**DEVIATION REVIEW
 AND DECISION FORM**

DEV18002

FLYING HORSE NORTH
(10% Road grade)

Section of ECM from Which Deviation is Sought: Section 2.3.2 Design Standards for Functional Classification

FLYING HORSE NORTH FILING NO. 1 STREET IMPROVEMENT PLAN OLD STAGECOACH ROAD - MINOR COLLECTOR STA. 3+55.28 - STA. 16+00.00			
DESIGNED BY	PRA	SCALE	DATE 08-11-17
DRAWN BY	PRA	(H) 1" = 50'	SHEET 11 OF 58
CHECKED BY	(V) 1" = 5'	JOB NO.	1096.11

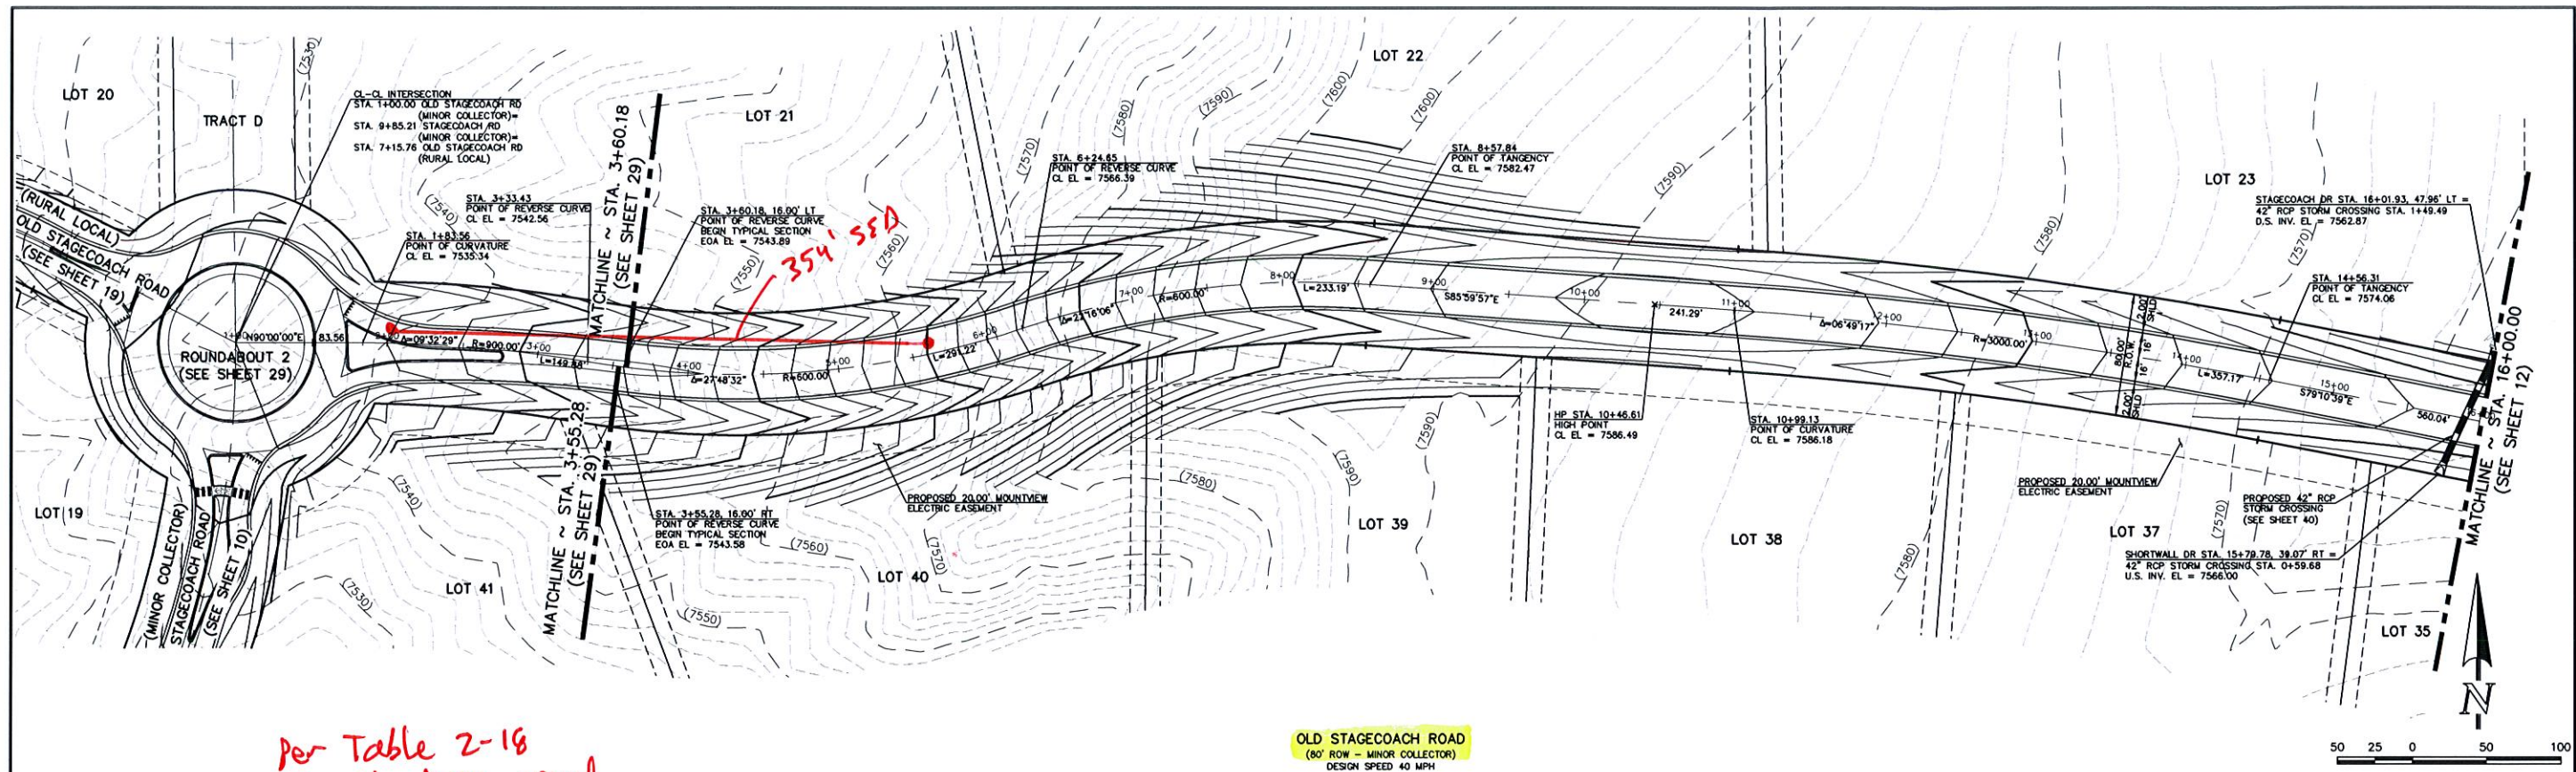
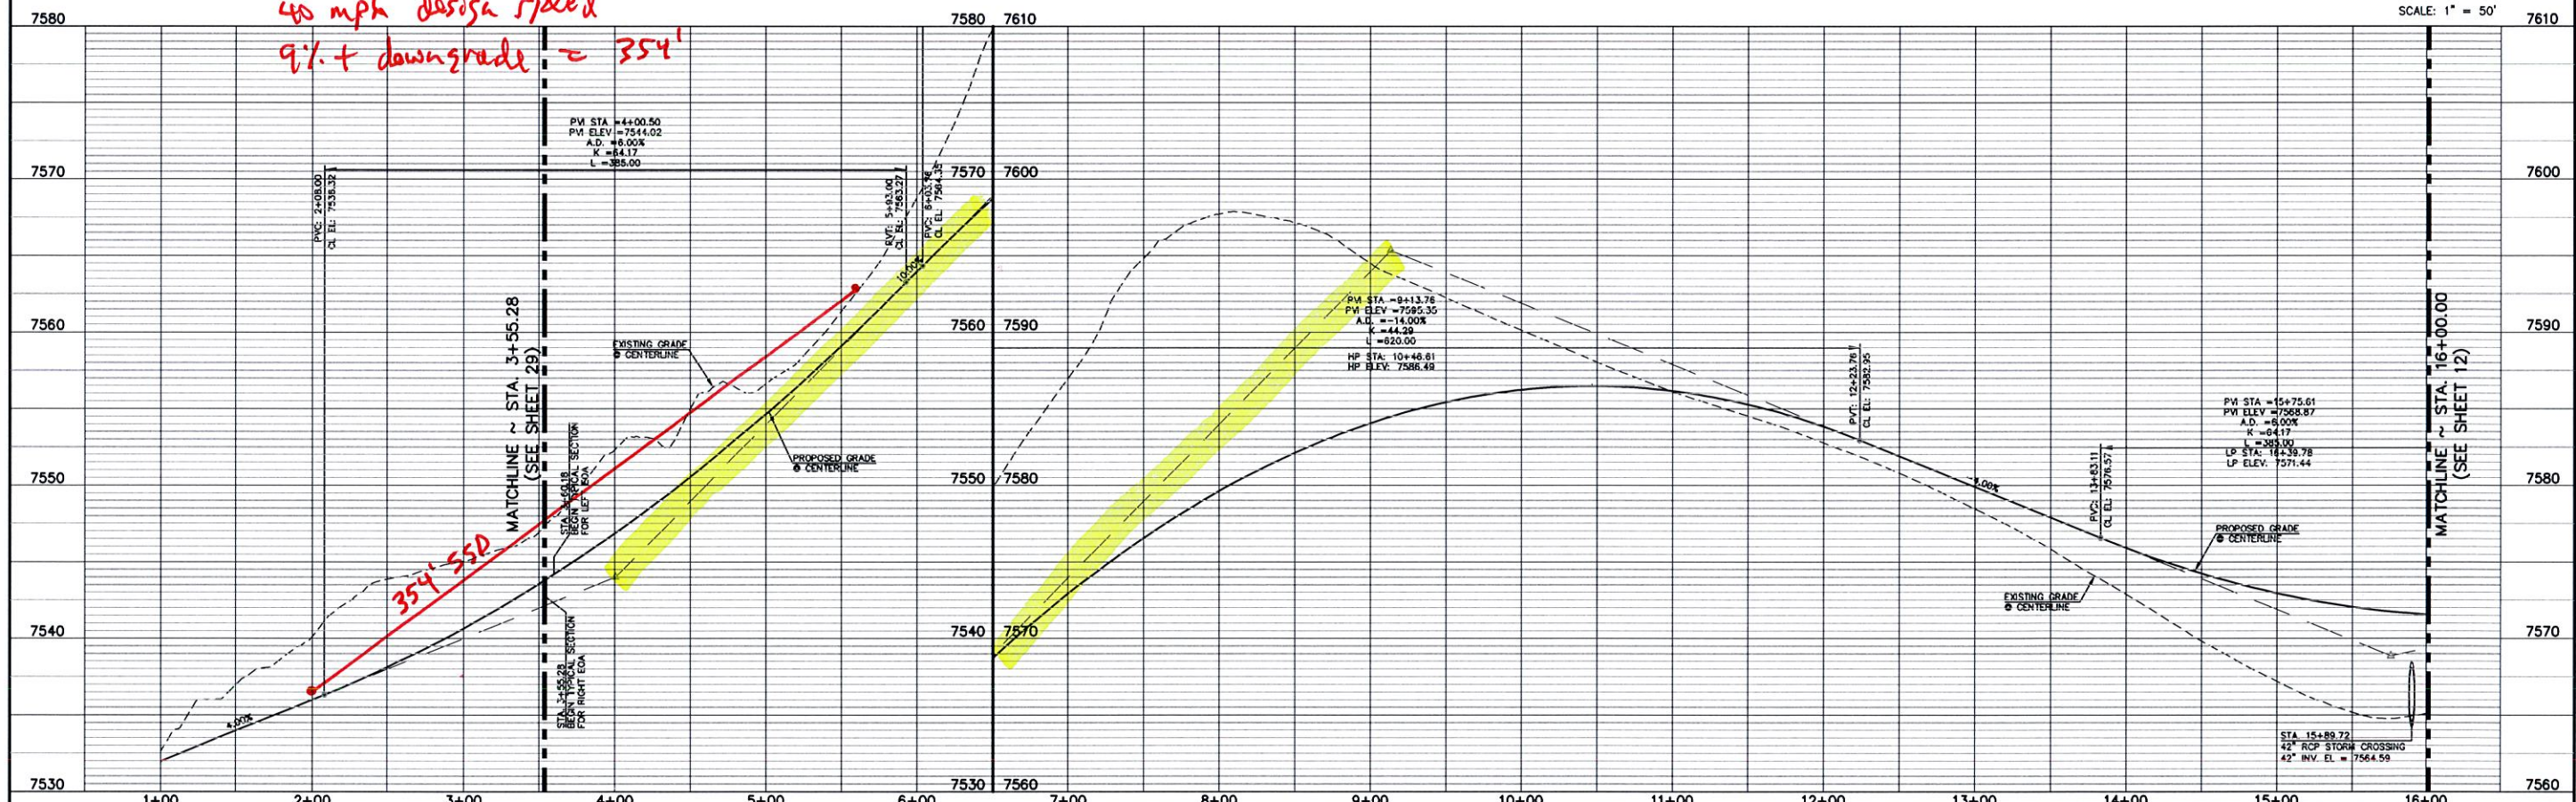
Design the length of vertical curve using adjusted K-values for the increased braking distances resulting from the downgrade (See ECM Table 2-18).

1. Provide the calculations for the required stopping sight distance for the 10% downgrades.

2. Provide calculations for the adjusted K-values based on the SSD.

2. Include a P&P of the road segment that shows the vertical curve geometry (AD, K-value, VC Length, slopes) and vertical sight distance on the profile. If it does not meet the requirement then propose how it will be mitigated.

10% Road
Grade Exhibit

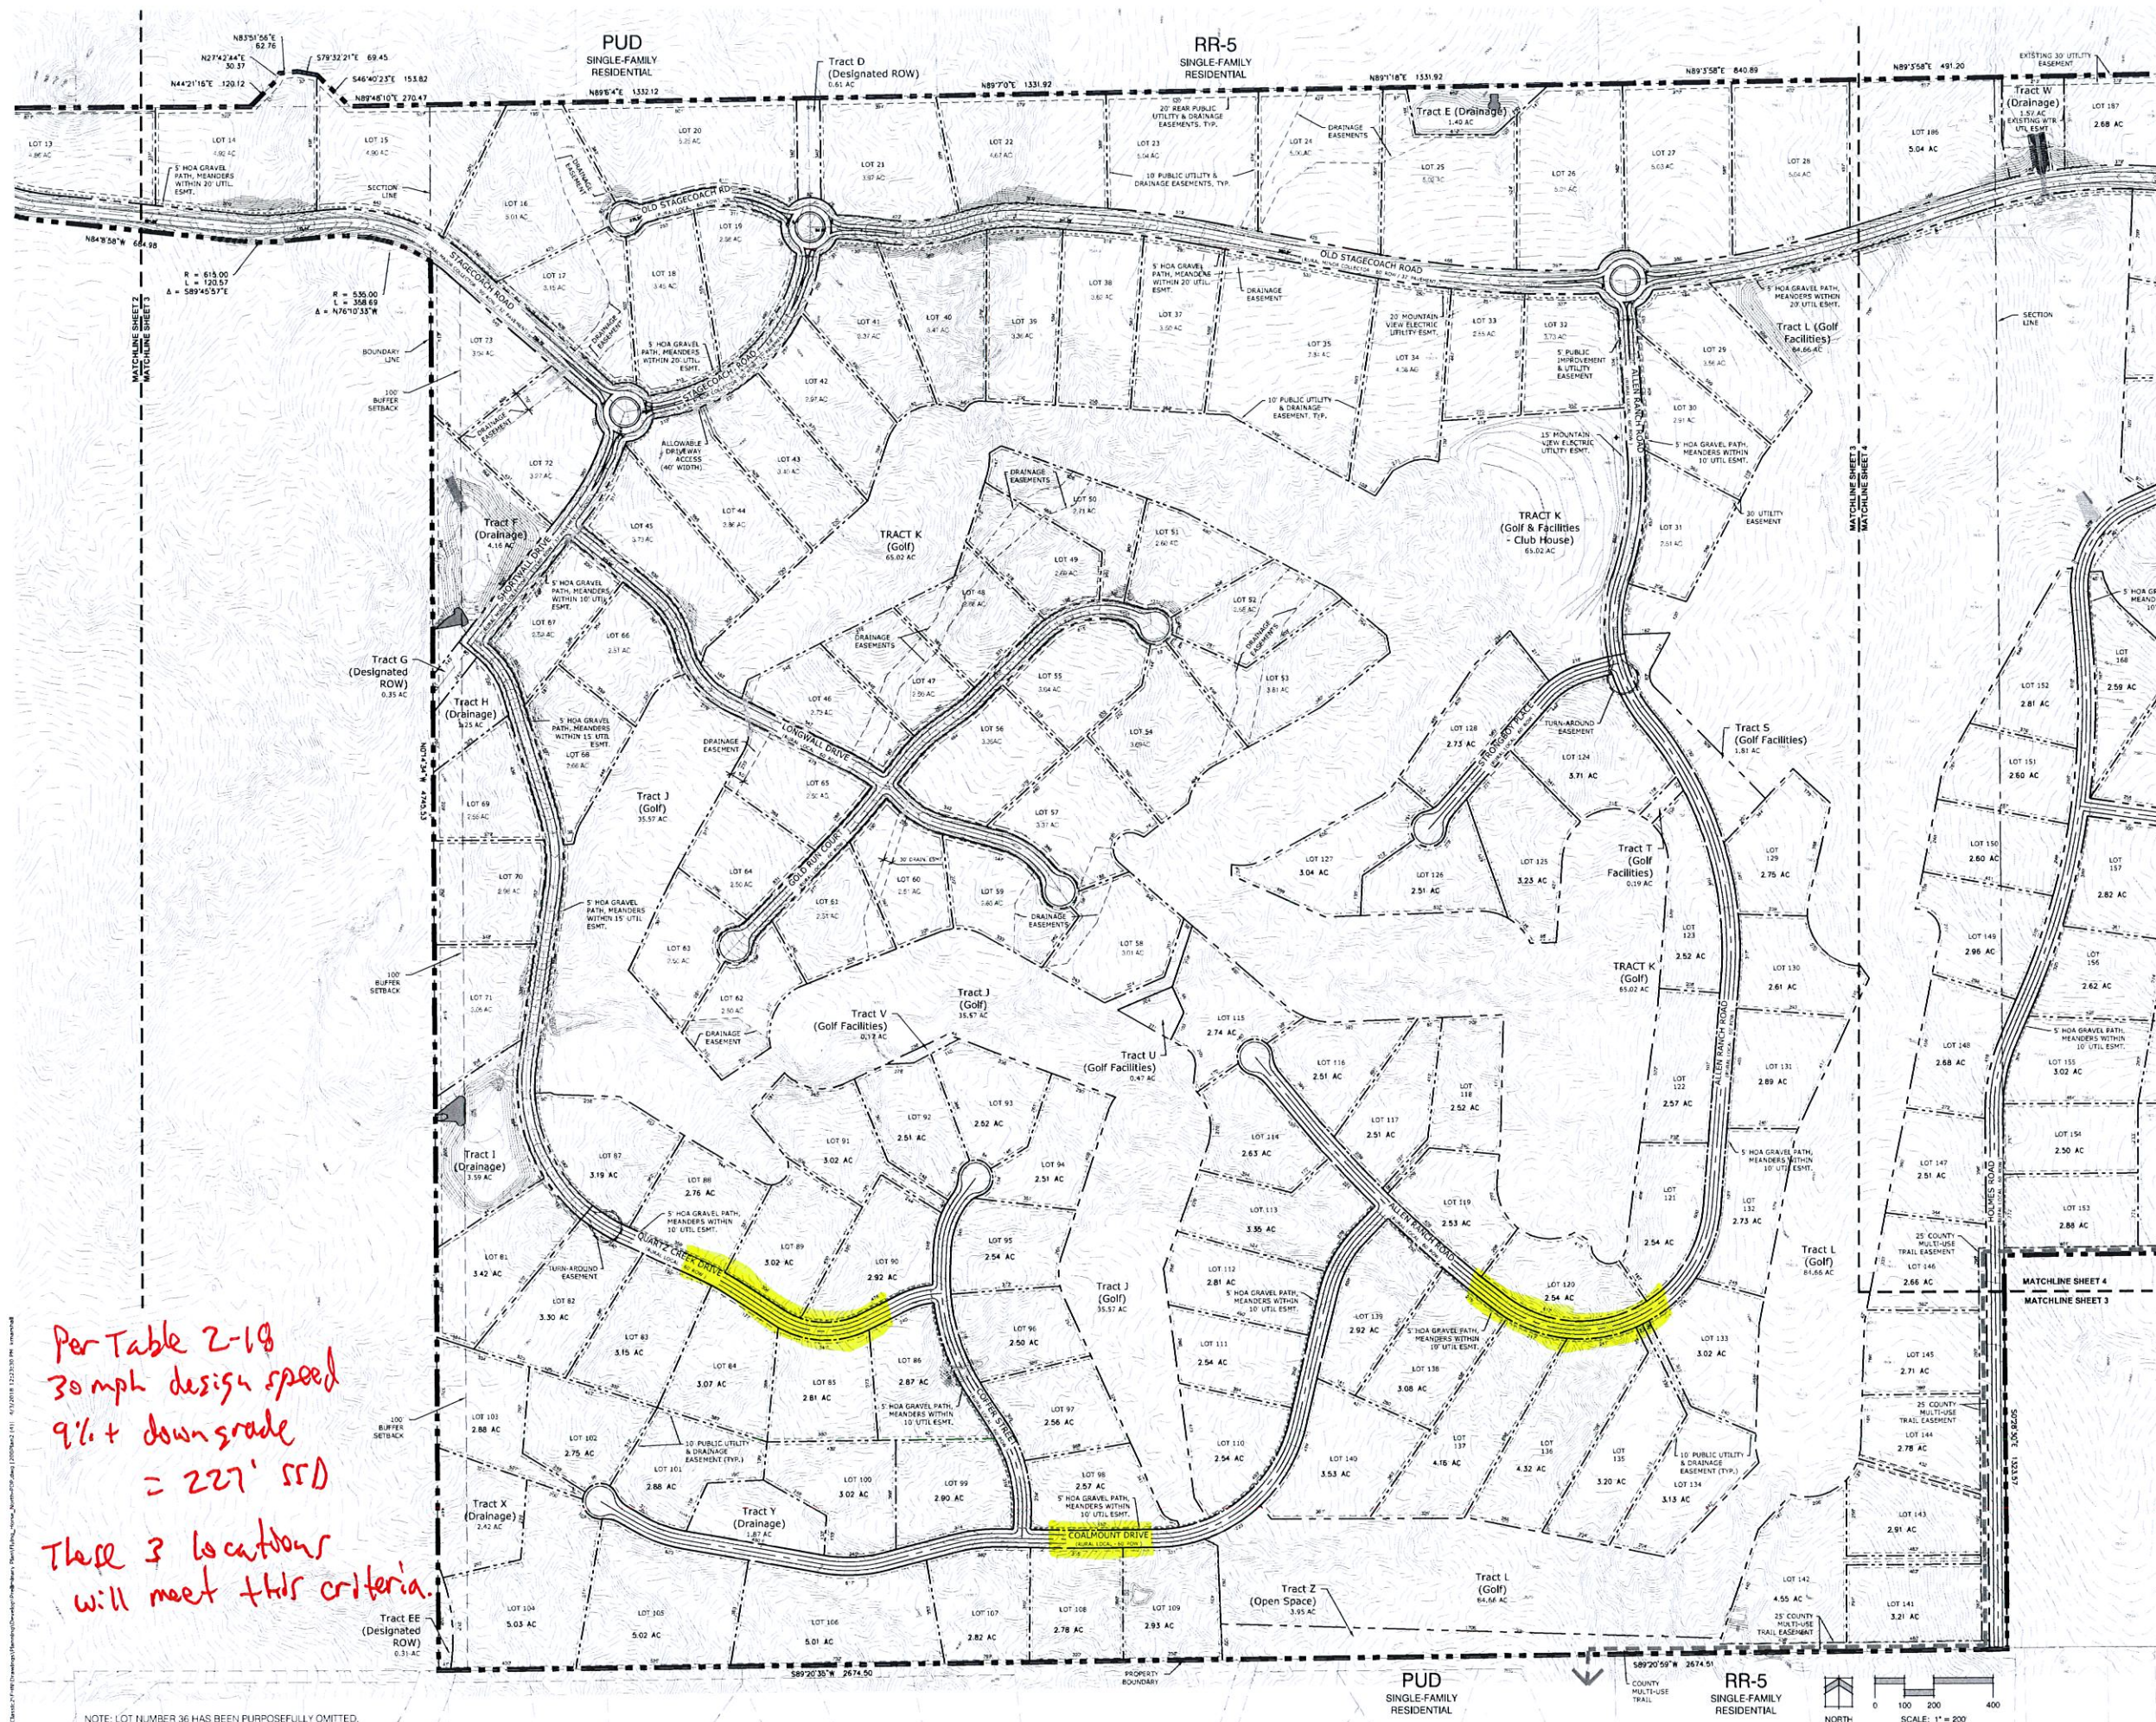
Include an exhibit highlighting the locations of the 10% road grades so approval or denial are for defined locations and not a blanket approval for the entire site.

Provide a specific designation for each location so they are readily identified in case conditions of approval are placed on specific locations.
